Re: Comment Response Letter – Bulk Land Plat Innovation Park III Tracts A-N
(PR-2023-008999 / SD-2024-00013)

Enclosed for your review are our responses based on comments received in your letter dated 2/28/2024. Below is a brief description of how the comments were addressed:

DETAIL E  
1" = 400'

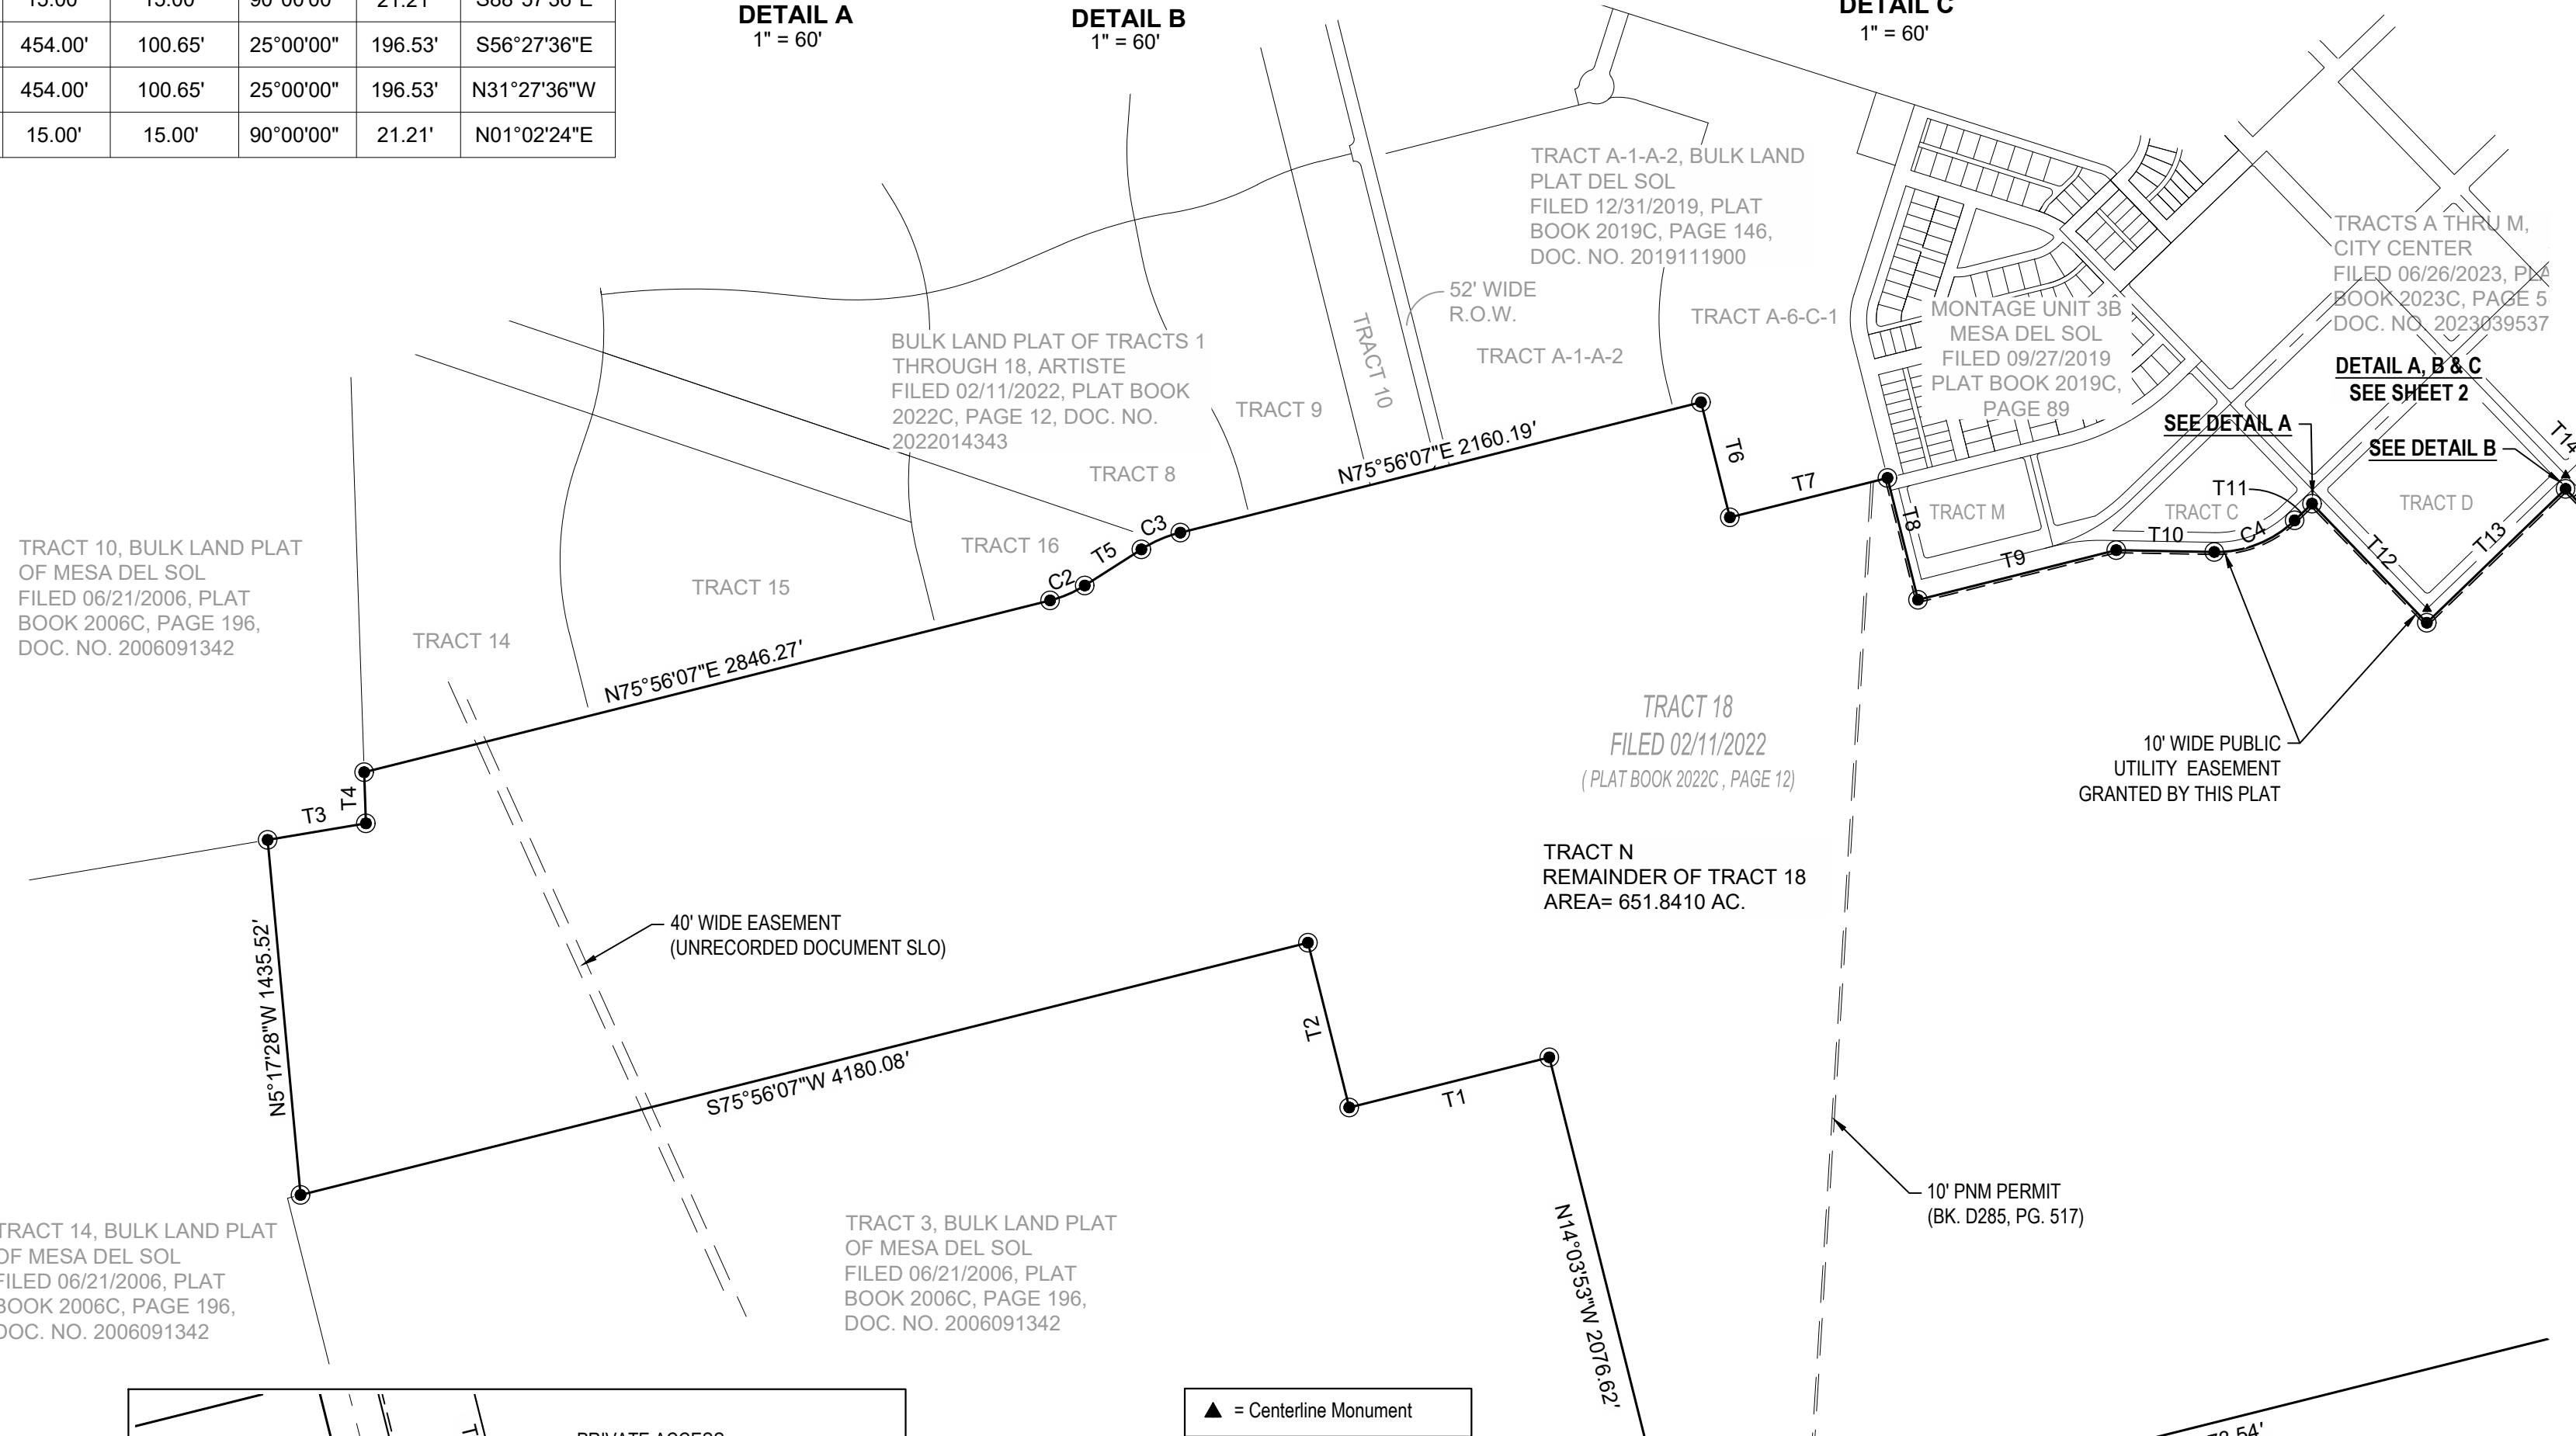
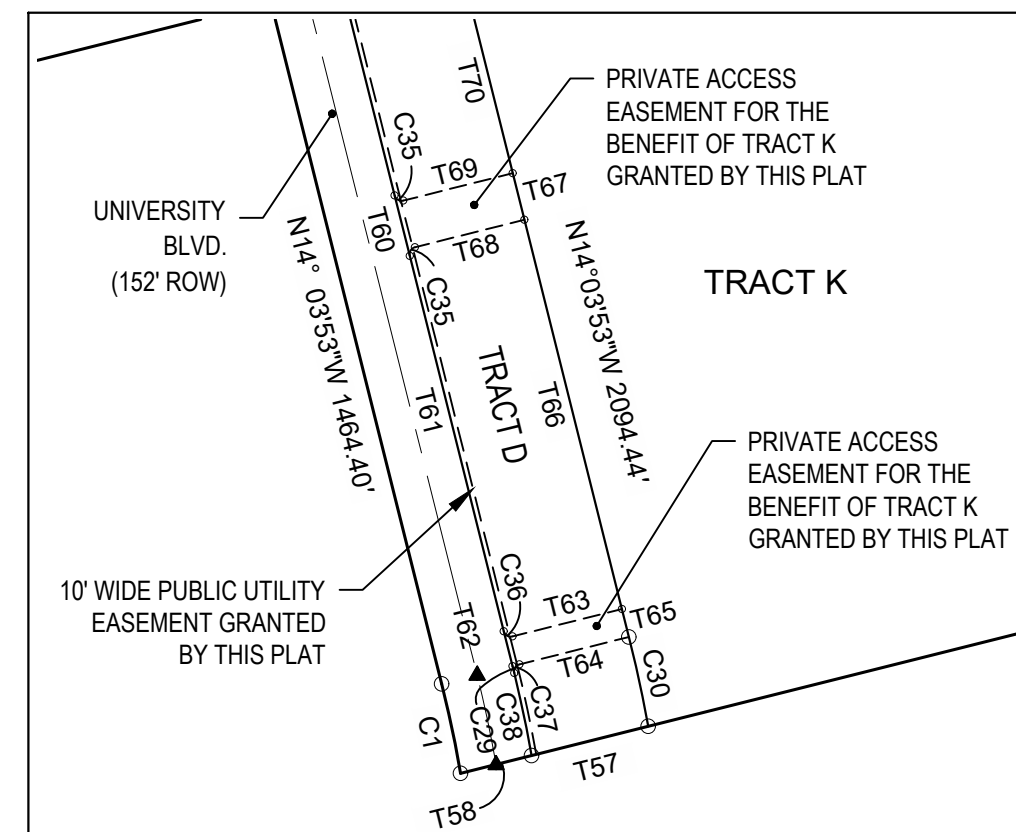
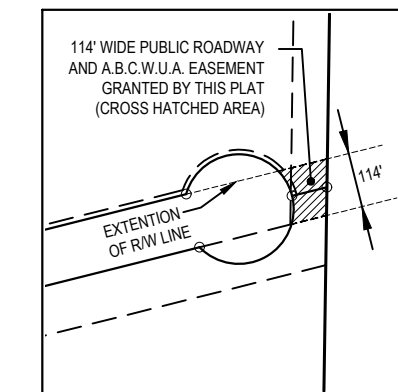
1. How will Tract 11, get service?
 - a. Please provide a public water and public sanitary sewer easement across Tract M or J to make the connection.
 - ***An easement has been added to the plat which will grant Public Roadway access and Public Water and Sewer access to the ABCWUA. It will be located at the end of the Cul-de-sac in order to serve Tract 1, if ever necessary.***
